From: Bennett , Laura (SPATIAL PLANNING PROJECT MANAGER)
<LauraBennett@barnsley.gov.uk>
Sent: 27 March 2024 10:08
To: Richard Mowat
Subject: FW: 2024/0122

From: Wilson , Claire (PLANNING ECOLOGIST) <ClaireWilson3@barnsley.gov.uk>
Sent: Wednesday, March 20, 2024 5:10 PM
To: Bennett , Laura (SPATIAL PLANNING PROJECT MANAGER) <LauraBennett@barnsley.gov.uk>
Cc: DevelopmentControl & DevelopmentManagement <DevelopmentControl@barnsley.gov.uk>
Subject: 2024/0122

Thankyou for consulting me on the above application. Please find my comments in relation to biodiversity below.

Figure 8. Post-development Habitats Plan

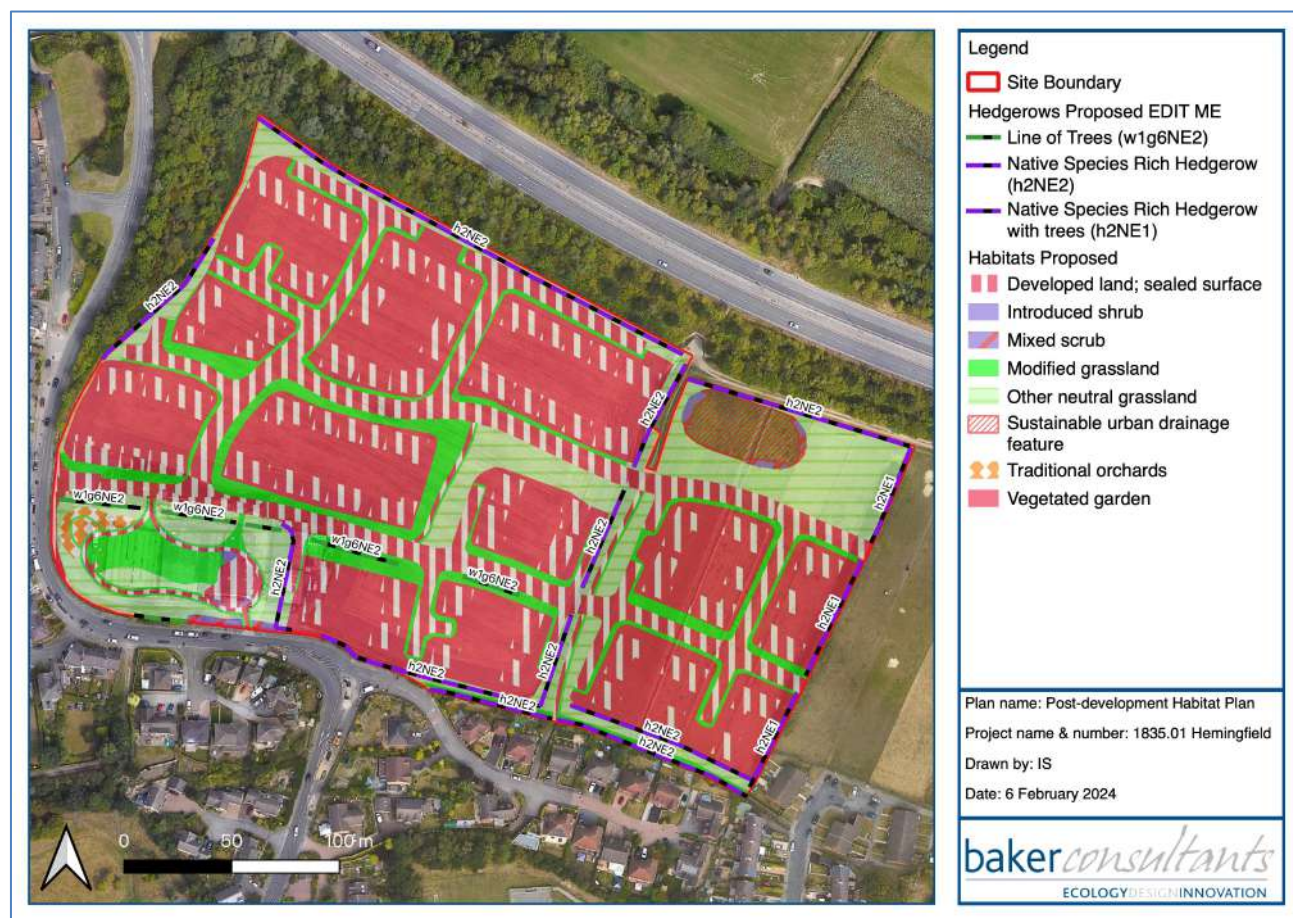
- I am content with the proposed habitats within the landscape masterplan and feel that they are appropriate and achievable. My only comment would be that the traditional orchard should be located in the north western corner of the site away from Hemmingfield road and closer to the woodland on the sites northern boundary.
